23 January 2021

EN020022: AQUIND Interconnector. Examining Authority's further written questions
Reference: TT2.16.7

TITLE: **Application document reference 2.7
Indicative Converter Station Area Layout Plans
Option B(i)
Sheet 2 of 3**

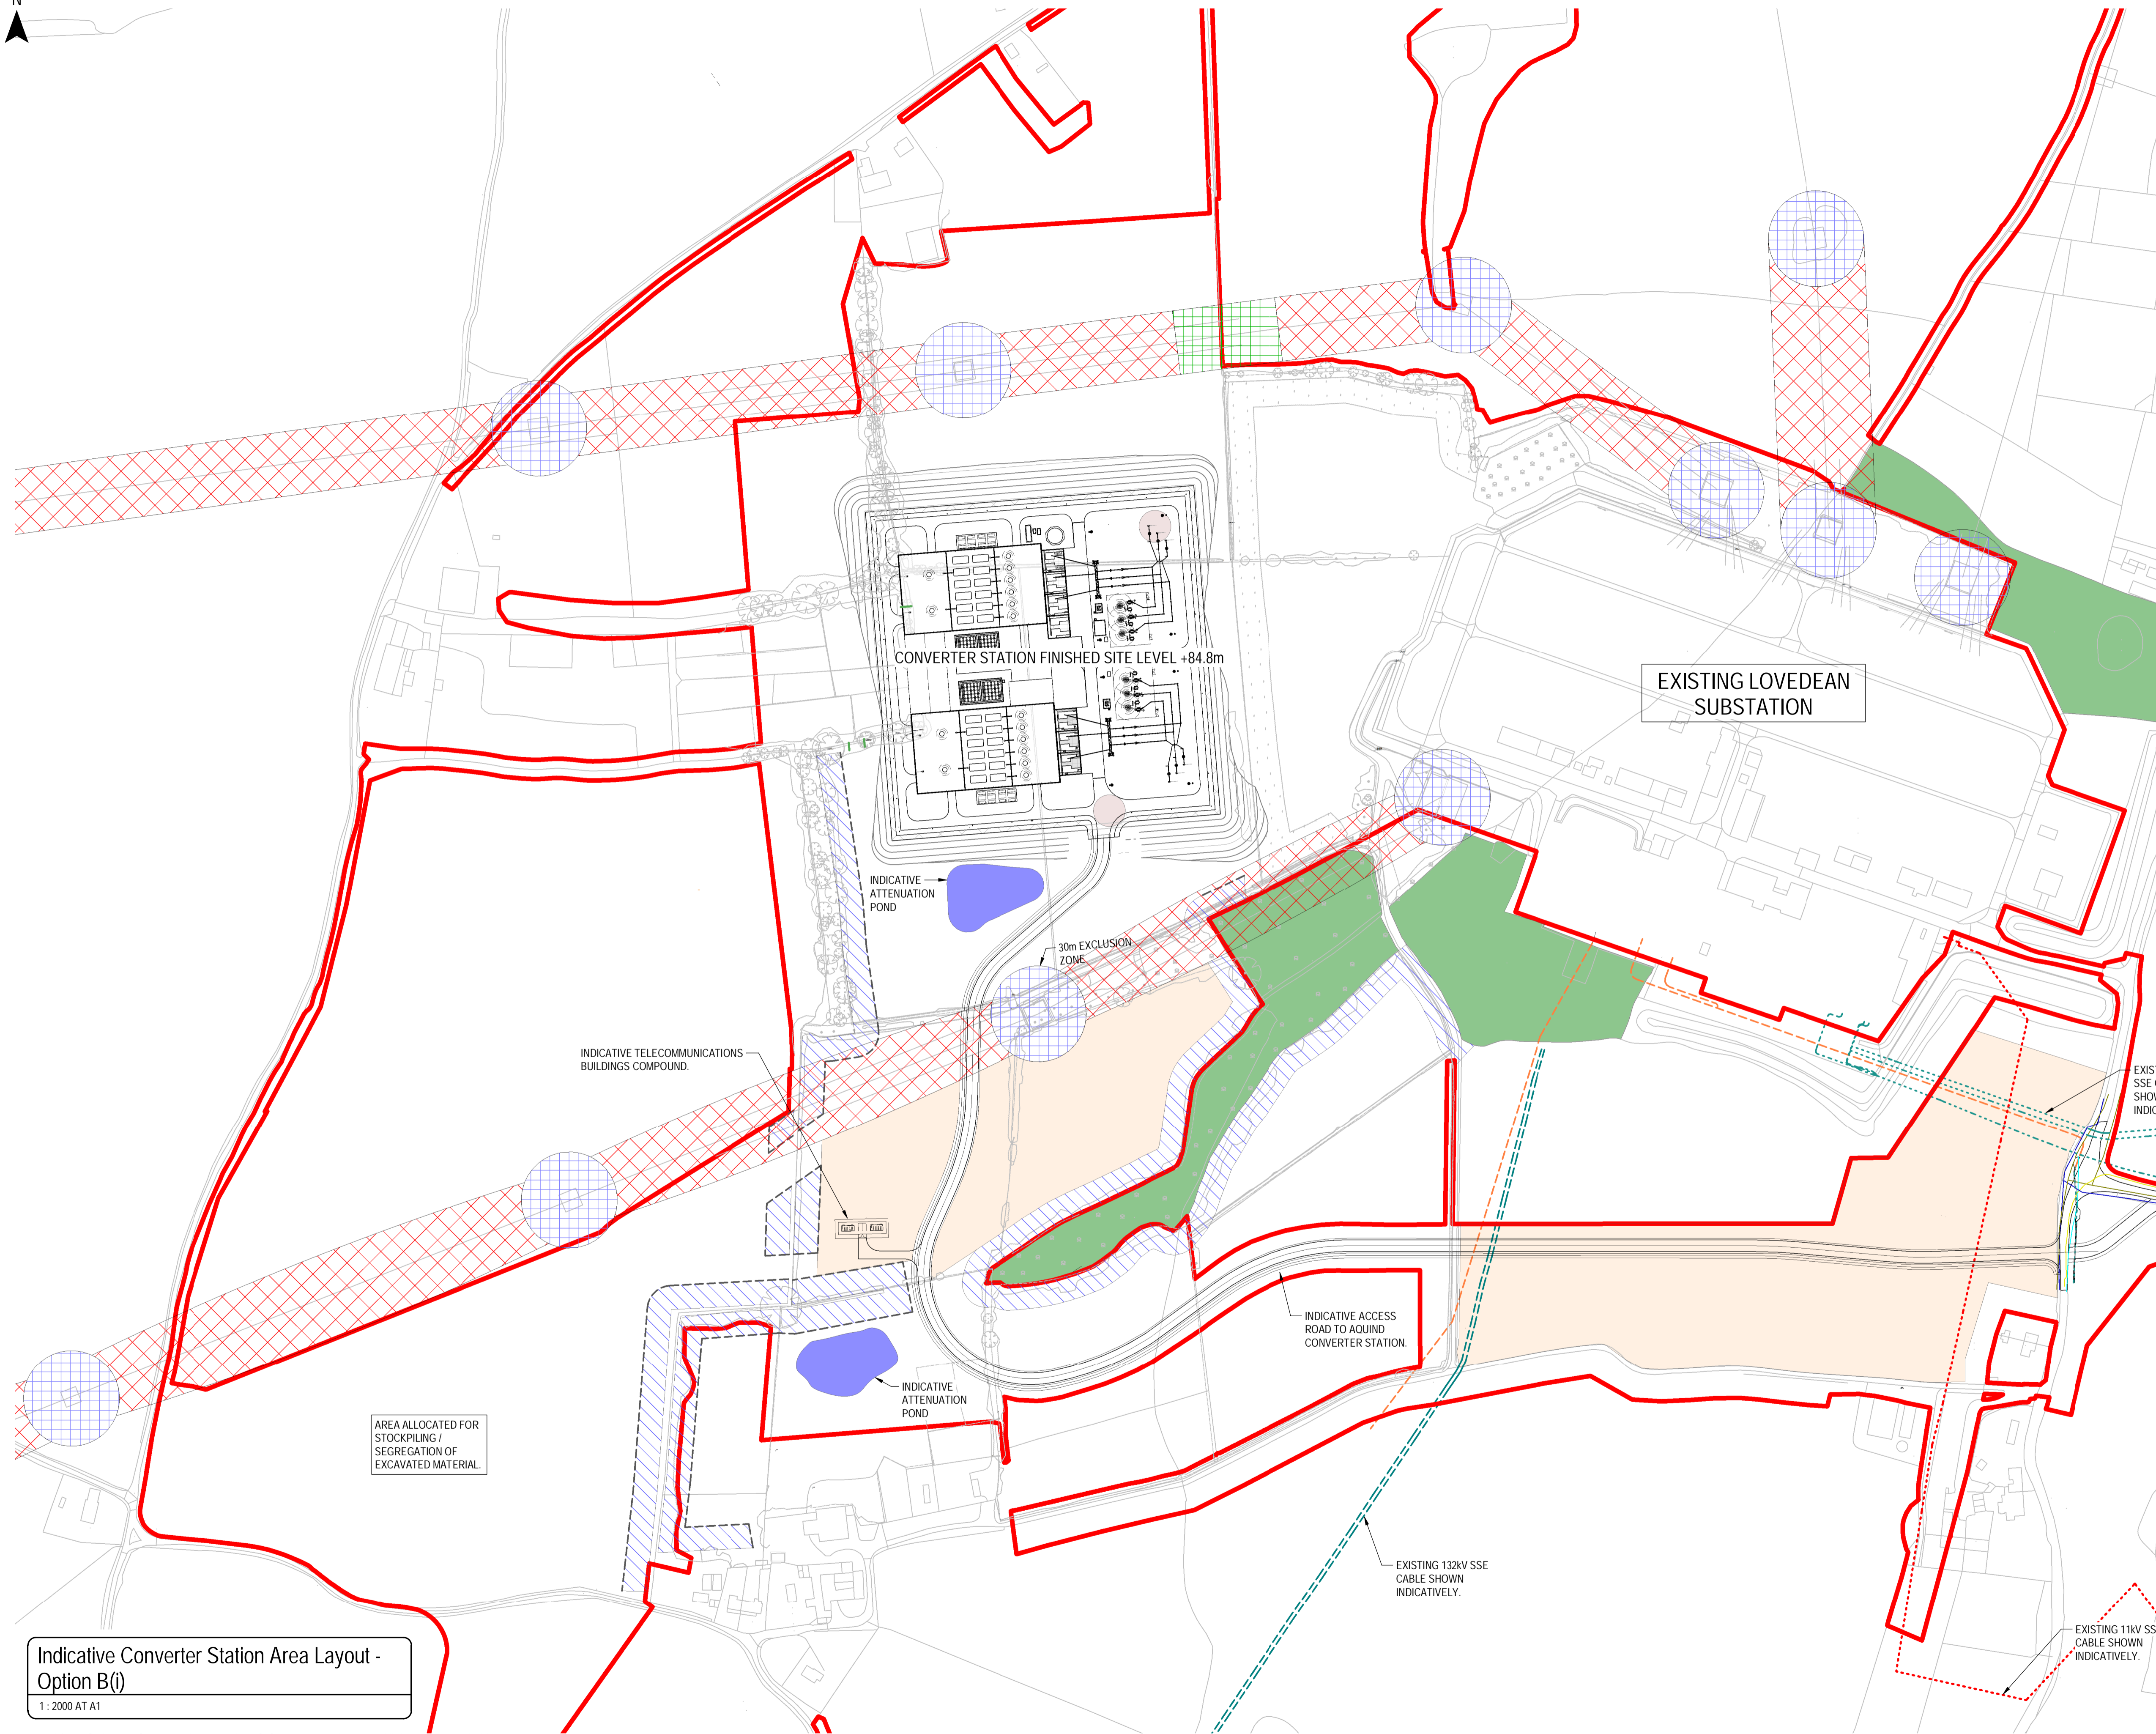
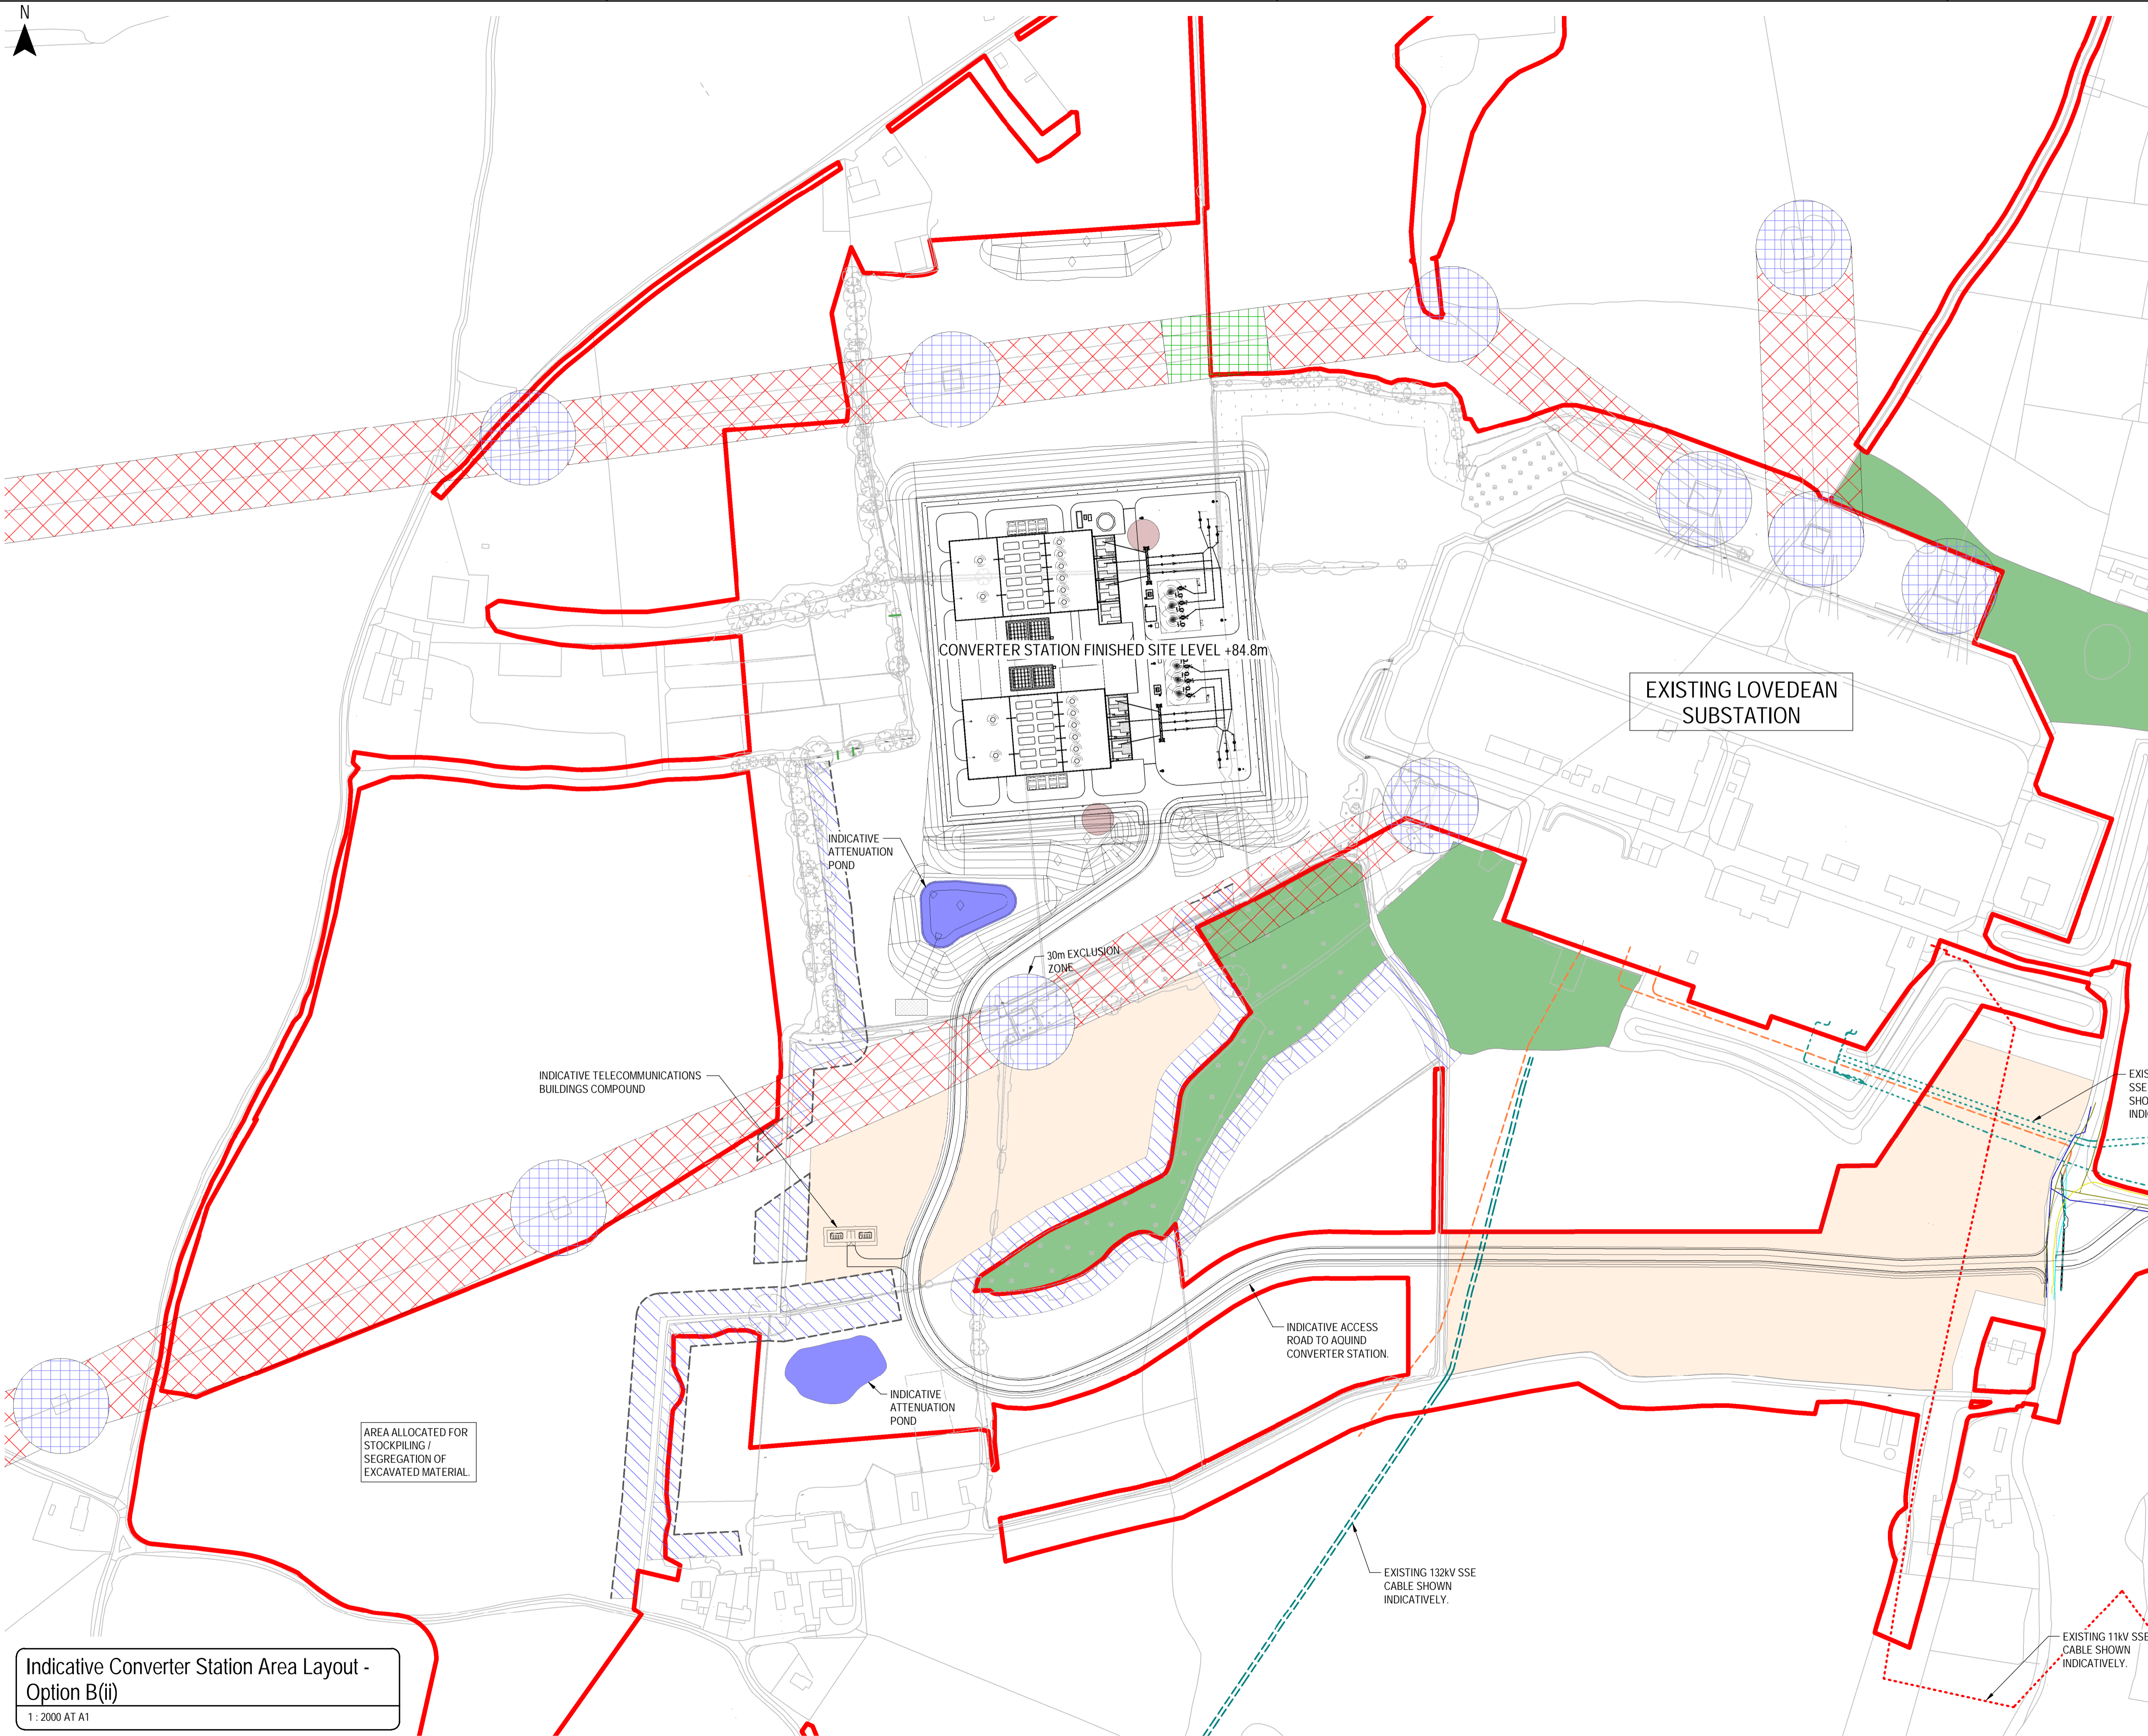
Should the answer to this query be that, as per point 3.5.1.3 in the Supplementary Transport Assessment that the transport of the cable drum to JB01 will be wholly accommodated by haul roads internal to the proposed converter station site, please can the Applicant detail the location of these haul roads within the Indicative Converter Station Area Layout Plan (Doc. Ref. 2.7).
